CITY OF ALBUQUERQUE

April 10, 2017

**Re: ABQ Assets Storage Bldg.
224 Muriel St. NE
Traffic Circulation Layout
Architect's Stamp 04-03-17 (L21-D072)**

TCL
1 of 1

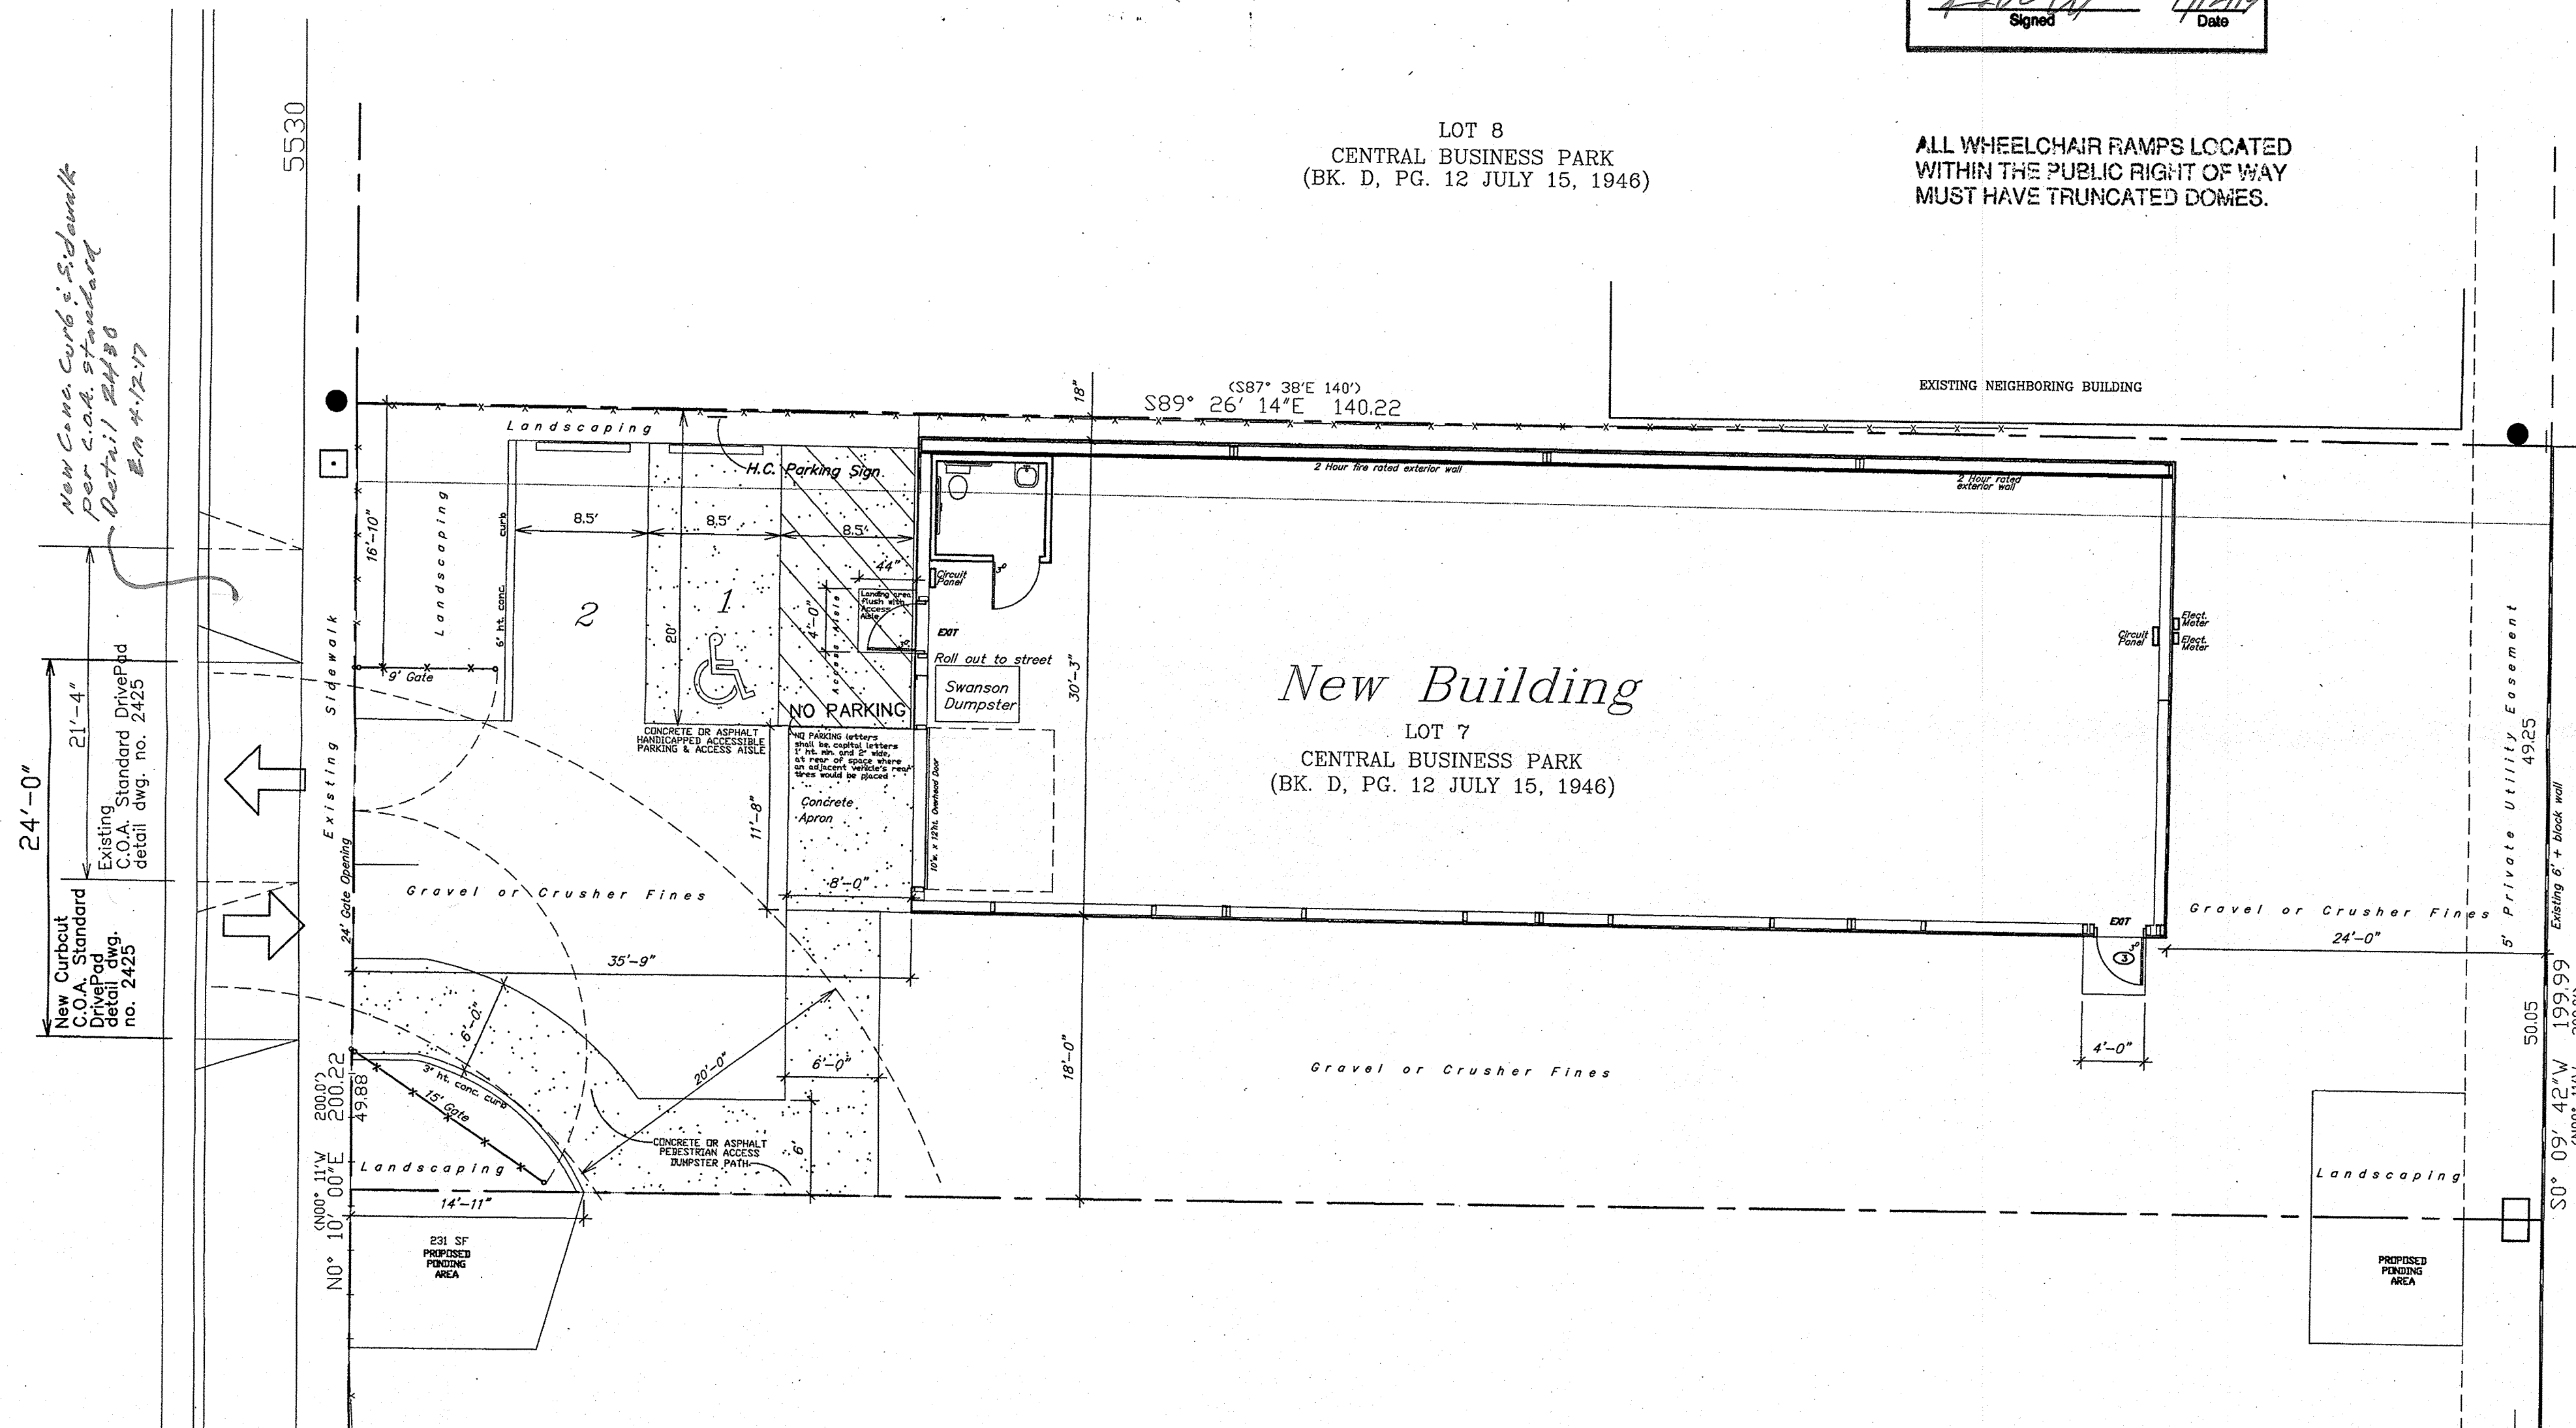
1. Unused curb cuts must be replaced with sidewalk and curb & gutter. A build note must be provided referring to the appropriate City Standard drawing. Please shift the drive entrance to the width of the gate.
2. ADA accessible pedestrian pathway should not be placed behind parking space or adjacent to a vehicular way. Vehicle and pedestrian/wheel chair conflicts should be avoided as much as possible. The pedestrian path can be moved to the other side of the lot as discussed over the phone.
3. Please clarify the entrance to the building from the ADA parking access aisle. Is the 44" by 4'-0" square flush with the pavement?
